From: Iqraa Malik [REDACTED]
Sent: 17 December 2021 13:18
To: Jack Dowling [REDACTED]
Subject: RE: Request for further information BE/180/21/HH

From: planning.responses@arun.gov.uk <planning.responses@arun.gov.uk>
Sent: 16 December 2021 14:19
To: Jack Dowling [REDACTED]
Subject: Request for further information BE/180/21/HH

Proposed Side & Rear Extension Plans and Elevations Planning
Date December 2021
Scale 1:200 1:1250

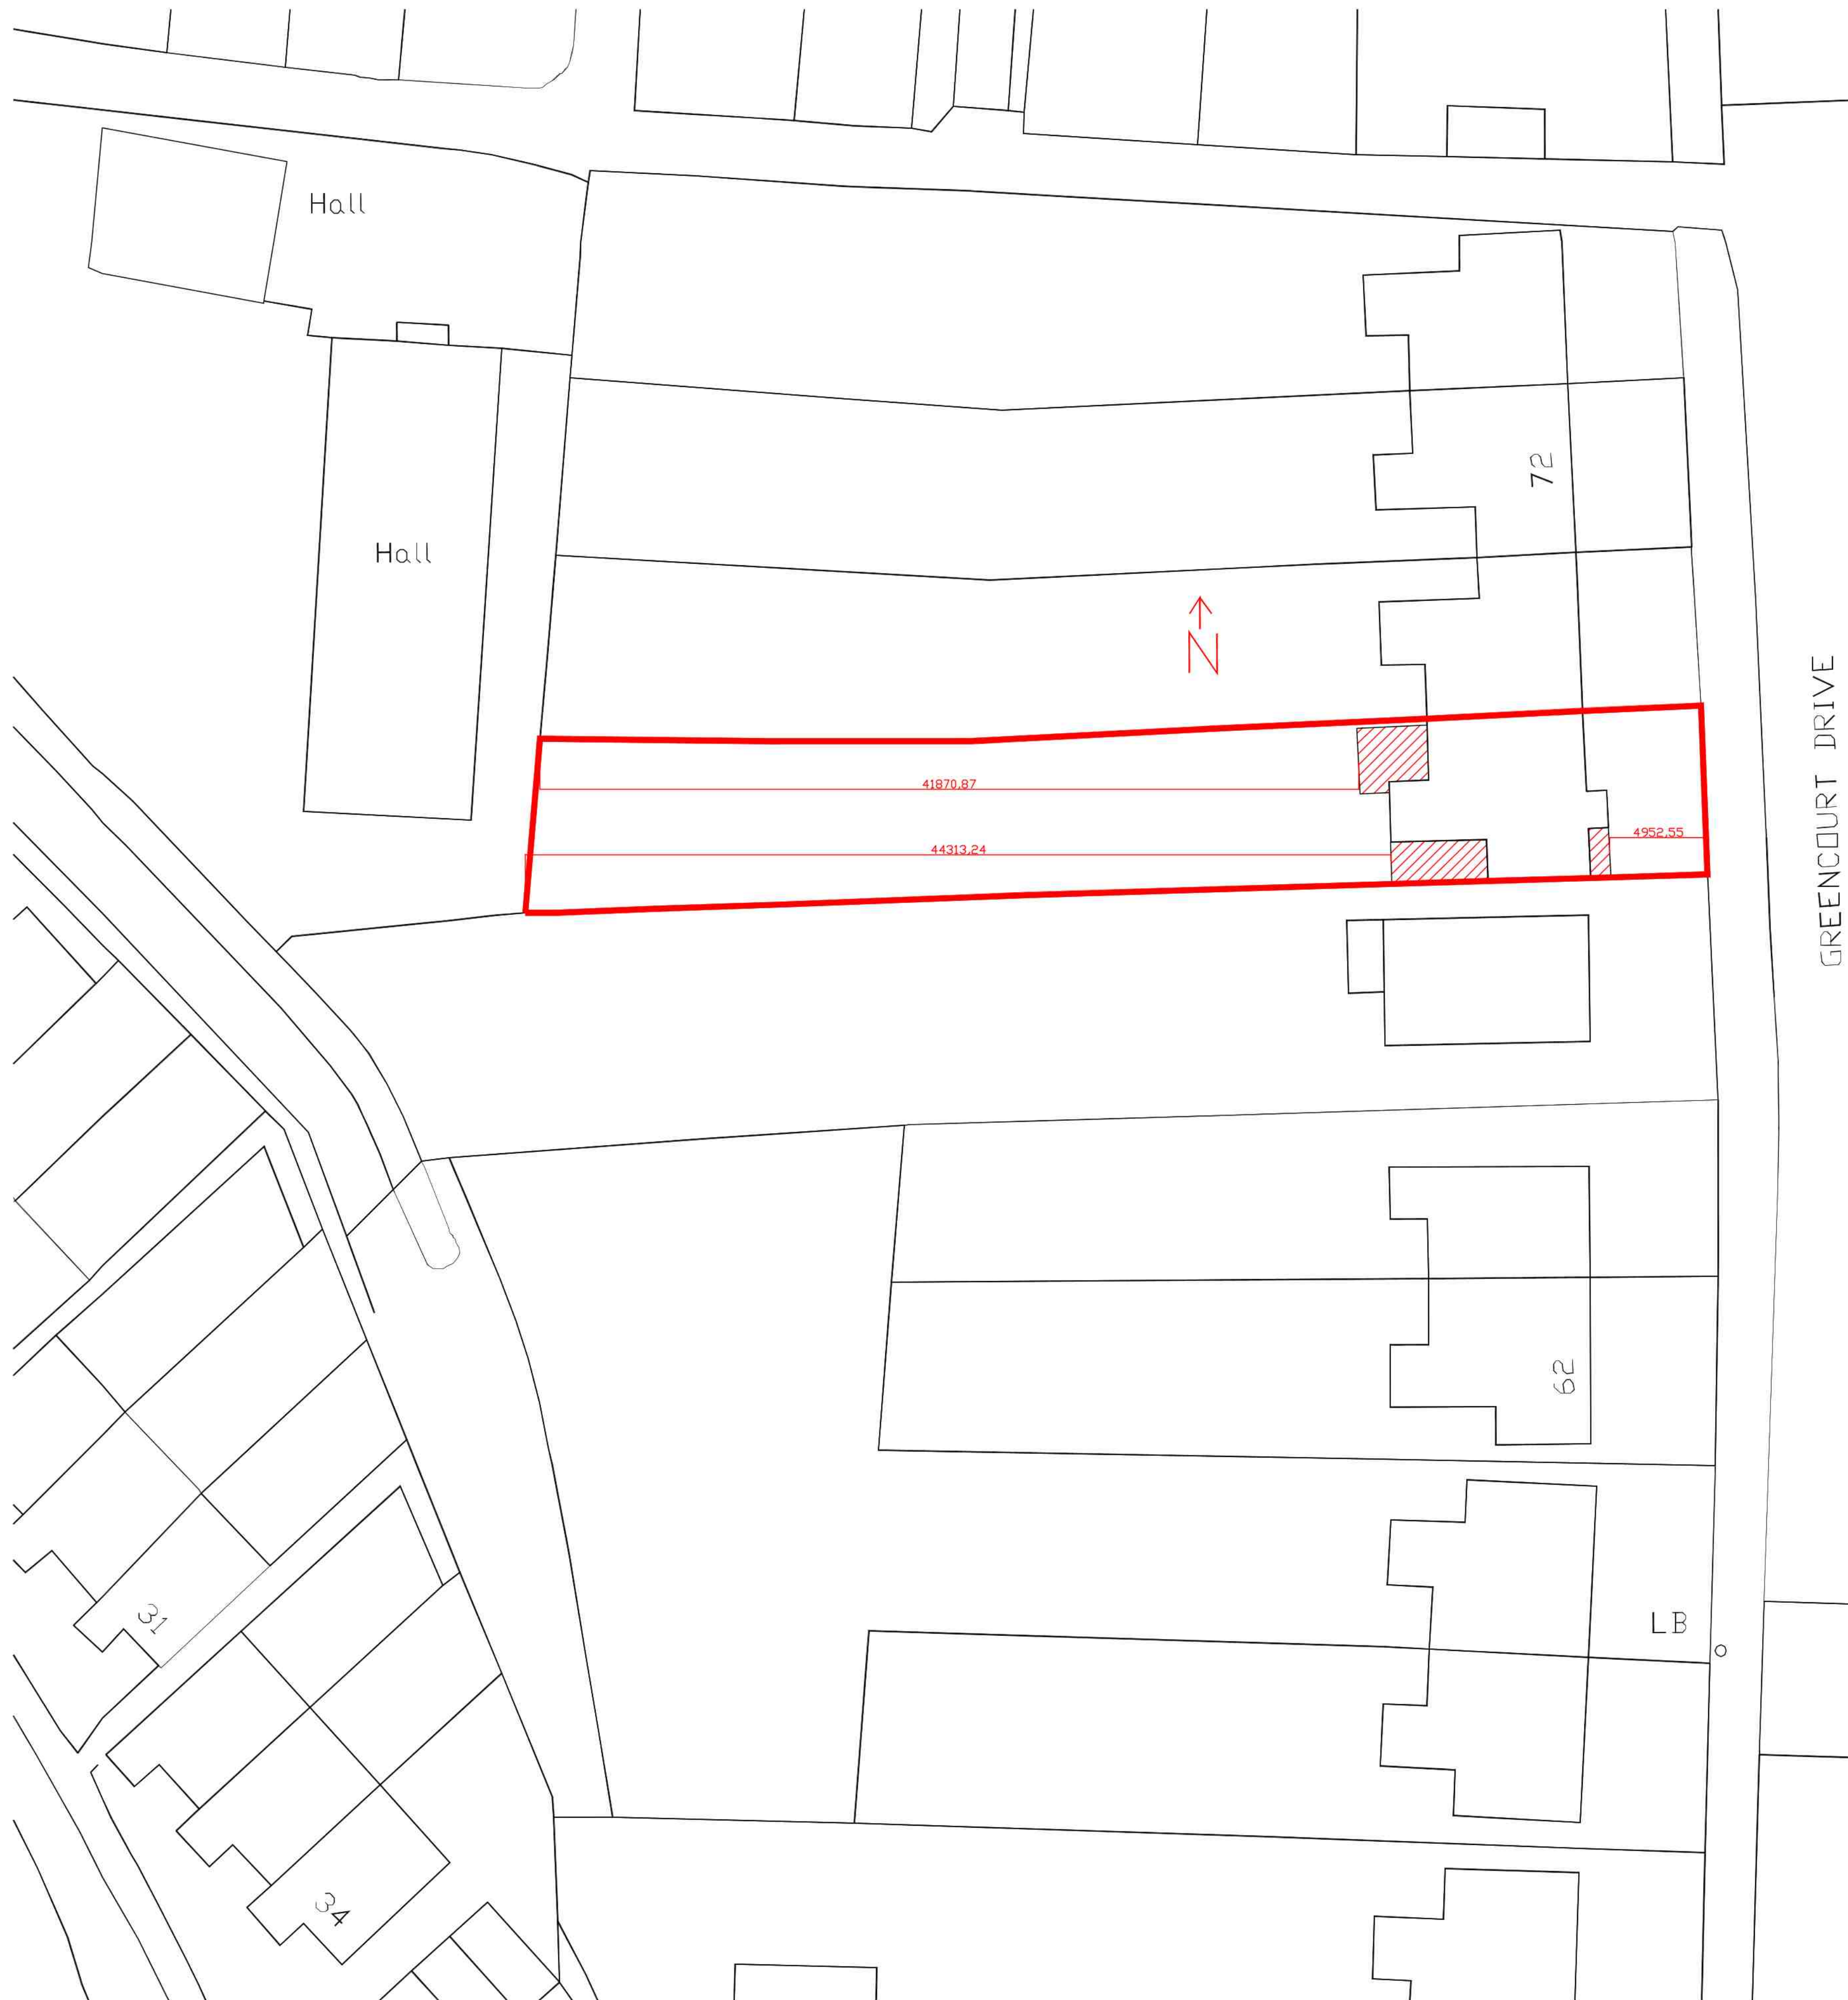
Thank you for providing the additional information. However, the Location and Block plans are missing a stated scale. Please amend.
